From: Sue Howell <Sue.Howell@arun.gov.uk>
Sent: 13 January 2022 16:15
To: Simon Davis <Simon.Davis@arun.gov.uk>
Subject: RE: Planning Consultation on: A/236/21/PL

Application No: A/236/21/PL

Site Address: Merry England Nursery Dappers Lane Angmering BN16 4EN

Description of Works: Variation of condition imposed under A/168/18/RES relating to condition 4-
landscape plan.

Figure Number: LSP/073/001

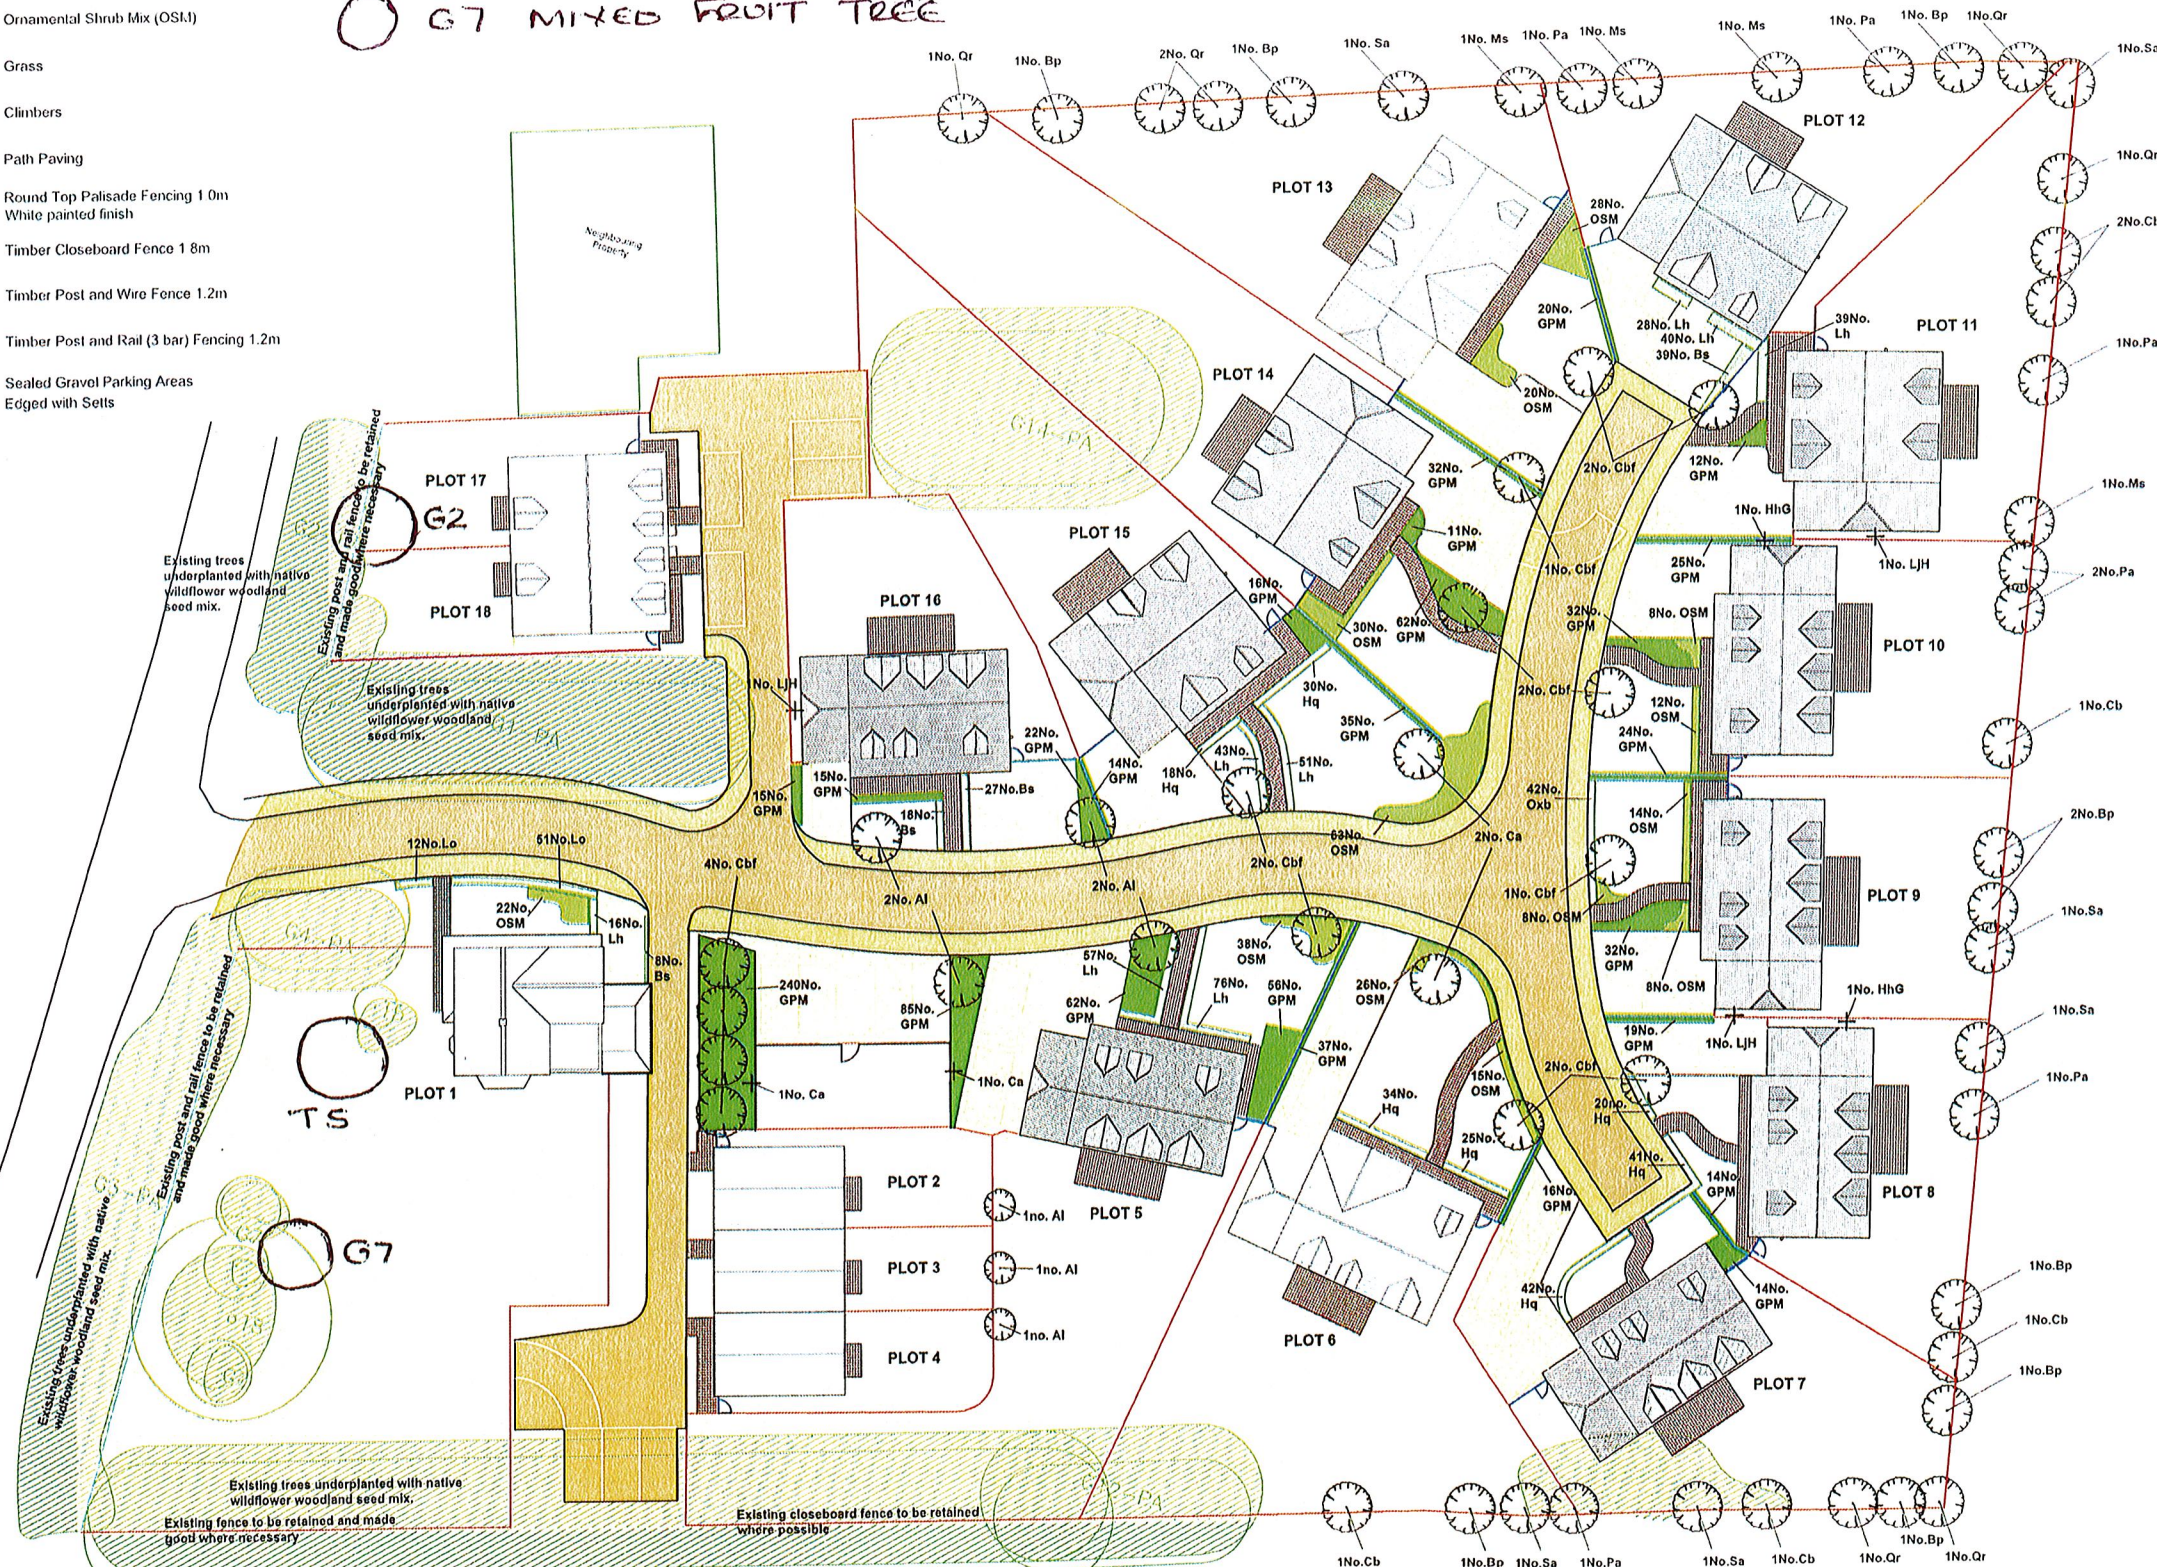
The information submitted in the revised Landscape Proposals LSP/073/001 REV C dwg is generally suitable, but please ask the applicant to confirm the species and the height at time of planting of the three additional indicated trees.
